Ribble Valley Borough Council
Housing & Development Control

Your ref 3/2022/0148
Our ref D3.2022.0148
Date 11th May 2022

Application no: **3/2022/0148**

Proposal: **Change of use and extension of the Black Horse Inn to 6 residential dwellings and associated landscaping and parking**

Title : Proposed Site Plan

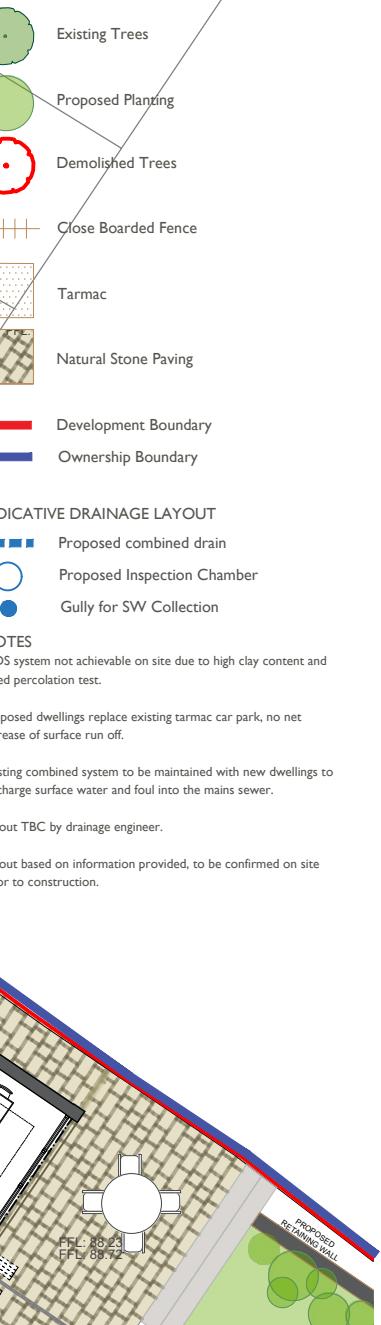
The LHA have also reviewed Daniel Wood drawing number 202 titled "Proposed Site Plan" and are aware that the site is proposing to erect a footway on the northern side of the private, access track. The footway will connect from the existing footway on Pimlico Road to the site access which serves the sites car park. The LHA are aware that the footway will be 1m wide.

While this does not comply with the LHAs guidance for a footway which requires a footway to be a minimum of 2m wide, the LHA in this case will accept the shortfall. This is because the LHA are aware that the footway will not be adopted by the LHA with the footway being located on a private, access track. Not only this but should the footway be 2m wide to follow the LHAs guidance, the access track will become too narrow for two-way movements to occur which would be unacceptable given the amount of traffic the previously approved applications as well as this proposal will generate. Therefore, the LHA will accept the shortfall.

The LHA have reviewed Daniel Wood drawing number 202 titled "Proposed Site Plan" and are aware that 9 car parking spaces will be provided for the site. This does not comply with the LHAs parking guidance which requires the site, which will provide 2x 4 bed, 1x 2 bed and 3x 1 bed dwellings, to provide 11 spaces. Therefore, there is a shortfall of 2 spaces.

Despite this the LHA will accept the shortfall, due to the site being located only 1km away from the centre of Clitheroe and there being alternative ways to travel rather than by car such as by bus with there being two bus stops located next to the site access which serves bihourly services to Clitheroe town centre and Sawley. Therefore, the LHA will accept the shortfall.

The LHA have further reviewed Daniel Wood drawing number 202 titled "Proposed Site Plan" and are aware that a retaining wall will be erected to separate the car parking spaces for the proposal and the car parking spaces which have been approved under 3/2020/0022 which serve the two approved dwellings.

The LHA have no objection to a retaining wall being built to separate the two sites but advise that the wall is no higher than 0.9m so that the wall does not obstruct the car parking spaces vehicular visibility.
